Recommendation Report for Lawful Development Certificate for a Proposed Use or Development

REF NO: AW/205/20/CLP

LOCATION: 36 Carlton Avenue
Aldwick
PO21 3LR

PROPOSAL: Lawful development certificate for the proposed demolition of existing garage and conservatory and replace with new rear extension.

| <b>PROPOSED &amp; EXISTING<br/>FLOOR PLANS</b> | <b>1:100<br/>@A3</b> |

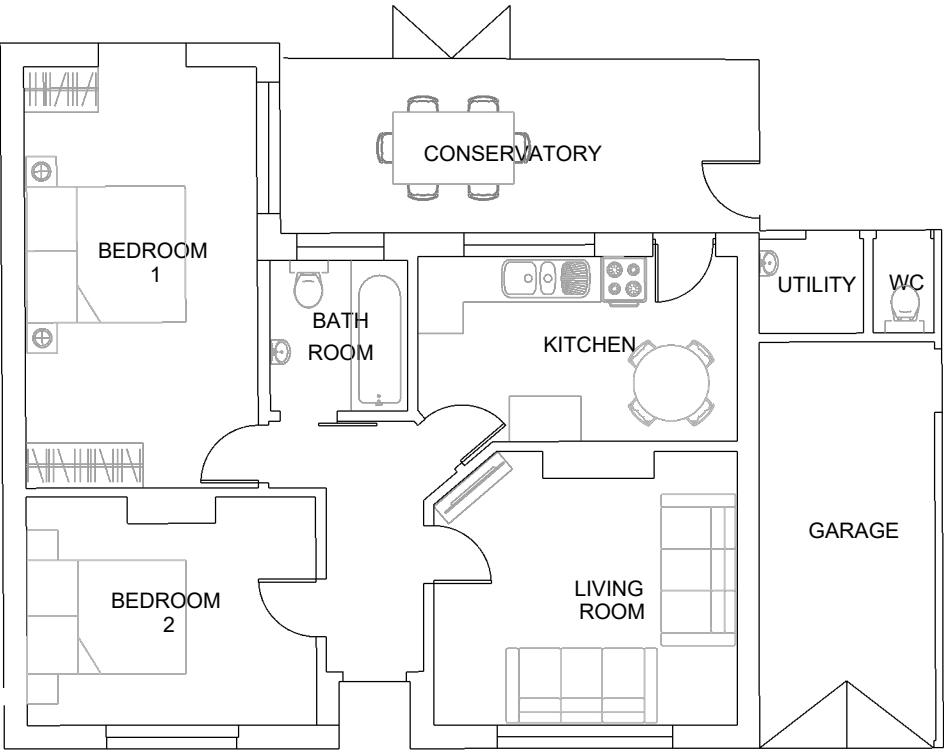
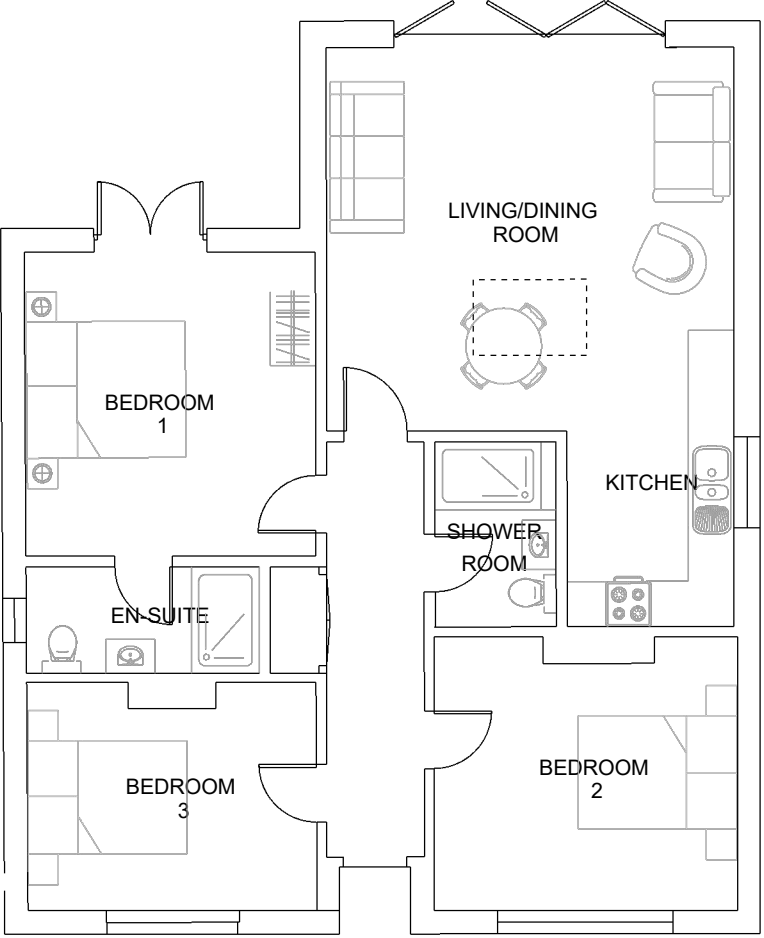
- The proposed development conflicts with Schedule 2, Part 1, Class A (g) of the Town and Country Planning (General Permitted Development) (England) Order 2015 in that it extends beyond the rear wall of the original dwellinghouse by 5.25m metres and no neighbourhood consultation scheme has taken place.

This needs to be completed on an application for a larger homes extension which allows for the neighbouring properties to be notified.
